SSD 6626 - SICEEP Darling Square - Mixed Use Residential Building within North-East Plot

Submission by:

21 November 2014

SSD 6626 Submission

Concept proposal
parameter plan shadows
for N + SE plots

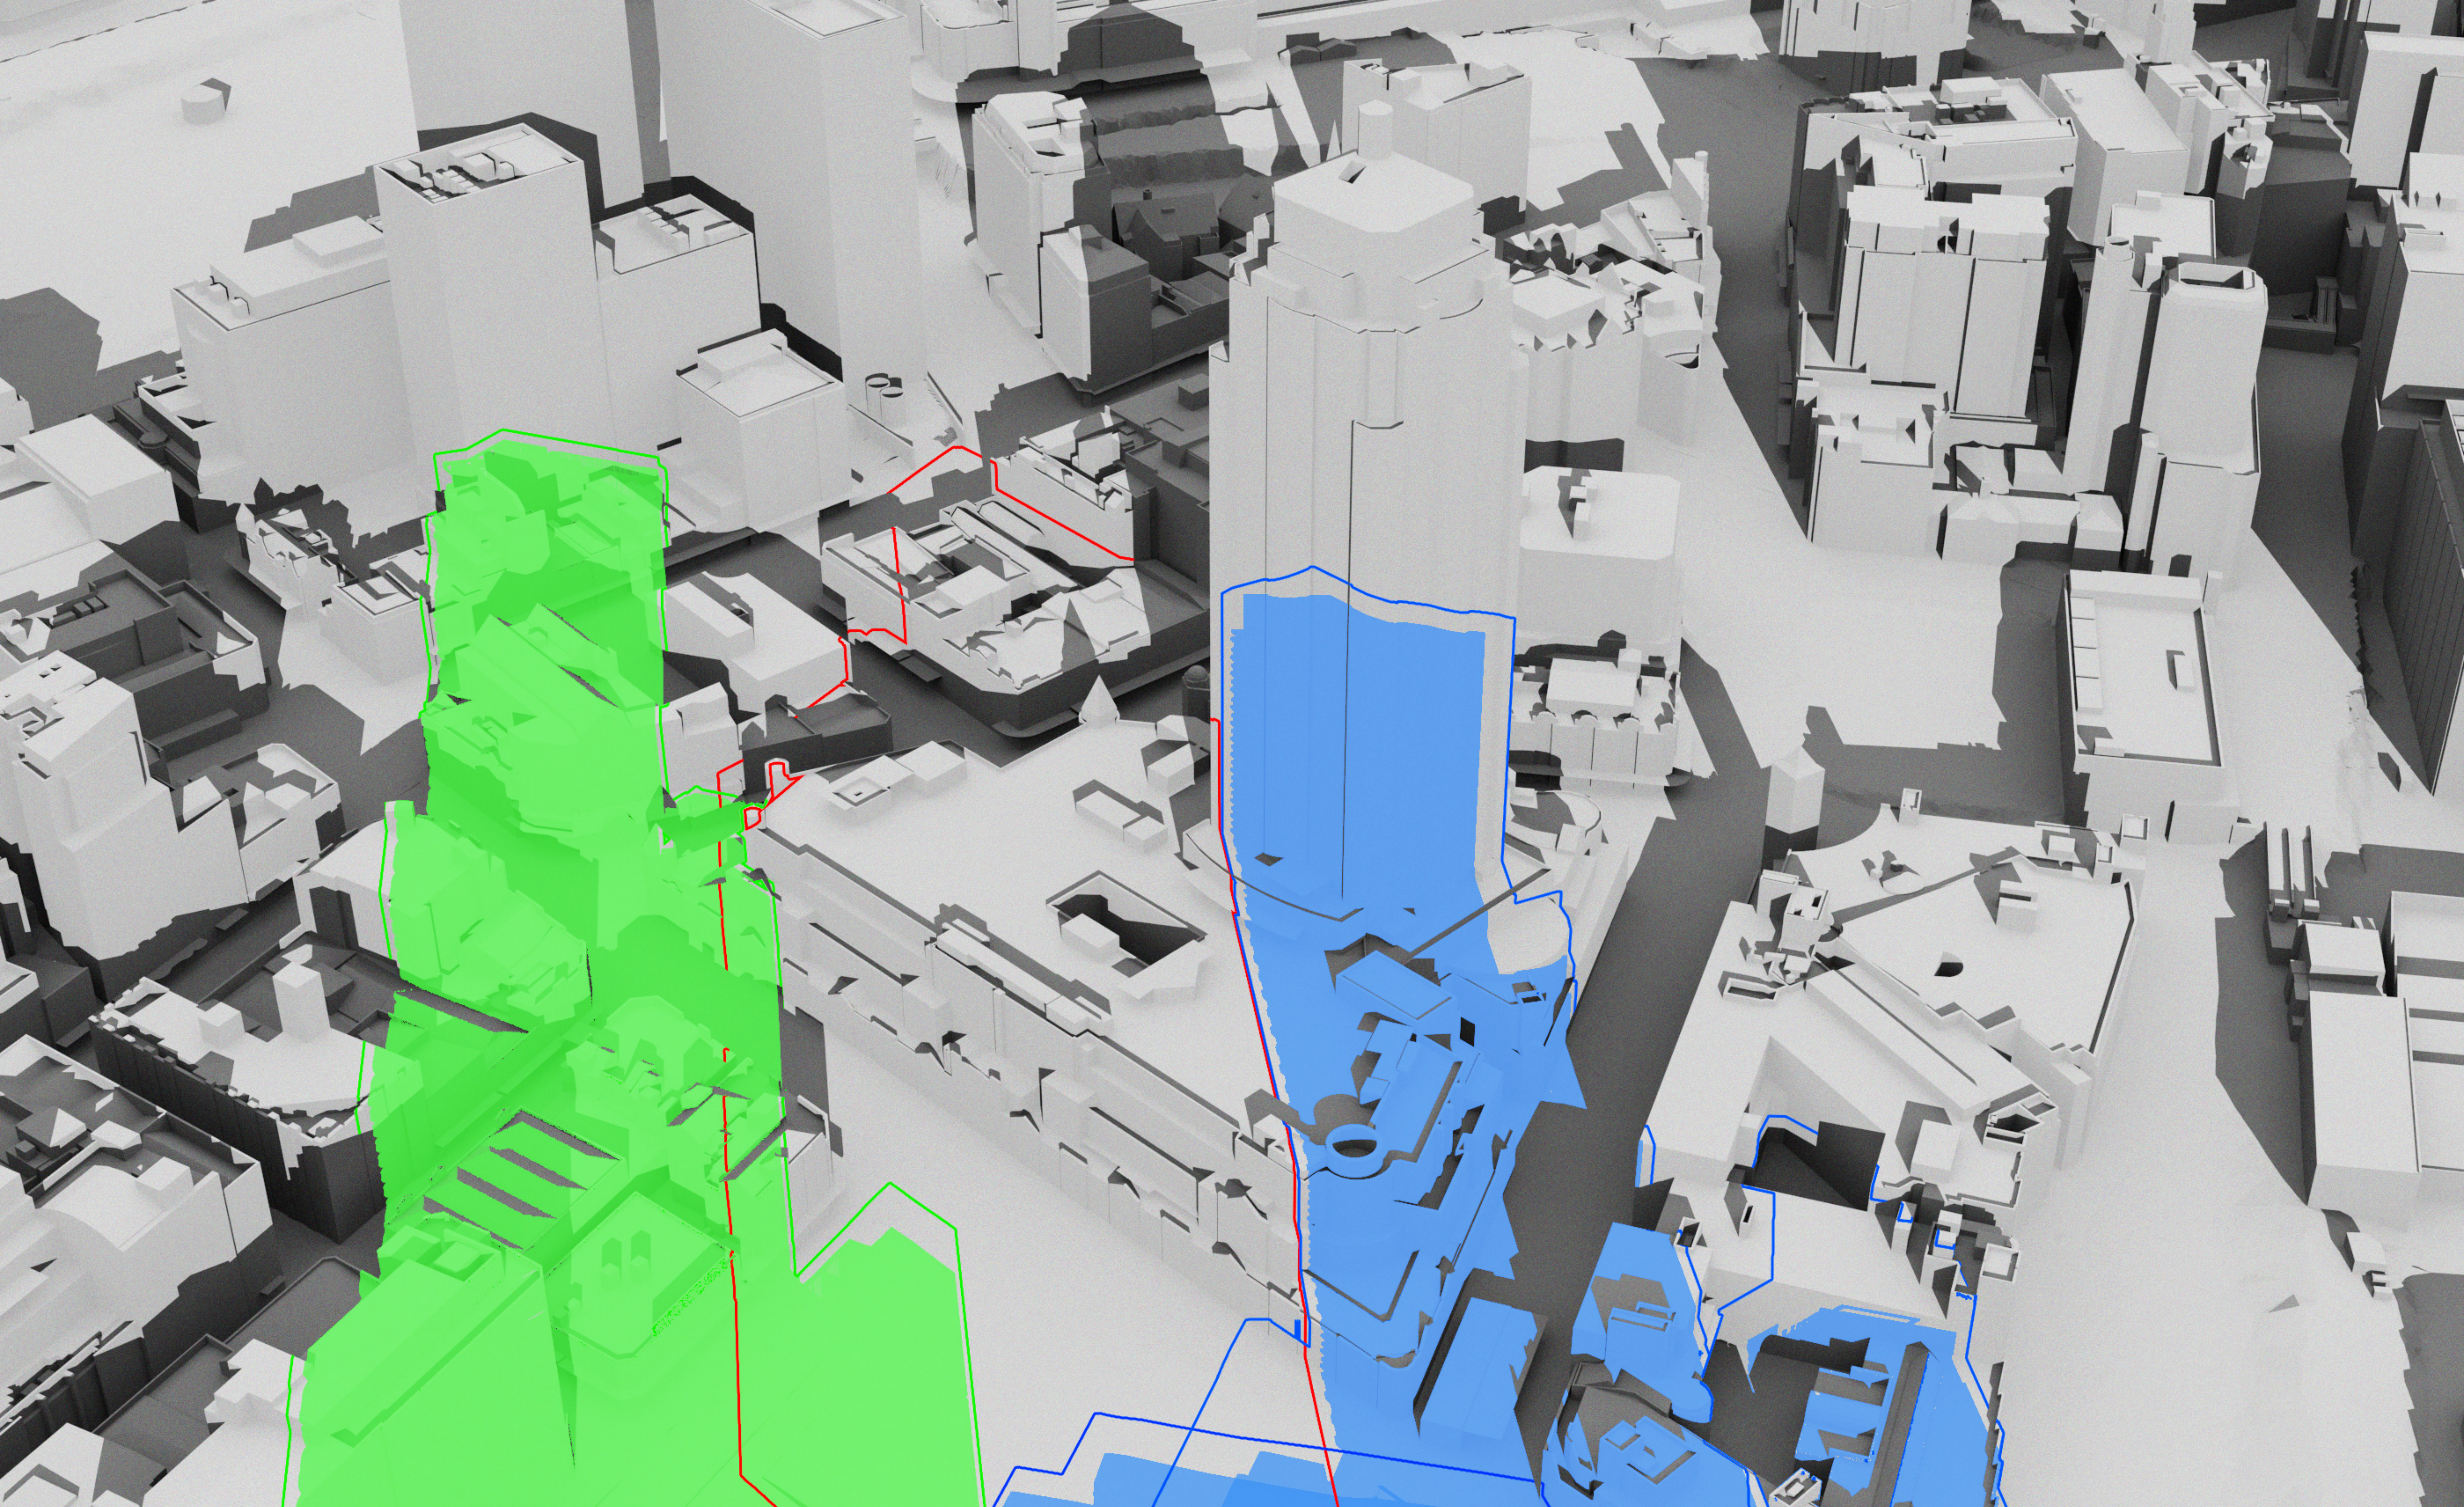
With respect to the podium of The Peak Apartments, the EIS states that " The landscaped podium associated with The Peak Apartments will continue to receive at least two hours of solar access, ensuring compliance with the intent of the Sydney DCP 2012.". Although this statement is true, two hours is a major reduction from the existing 21 June daylight access of about six hours.

Excessive overshadowing of public open space - the new square - "Haymarket Square"

We agree with the City of Sydney's view that "excessive morning shadows are cast into the outdoor and café areas in the new square by new surrounding building edges. In order to improve morning sun access to the square in winter, it is recommended that the building heights lining the new square be reduced and the floor area relocated to the surrounding streets podium edges..." Source: City of Sydney, SSD 5878 (SICEEP)The Haymarket submission, page 34.
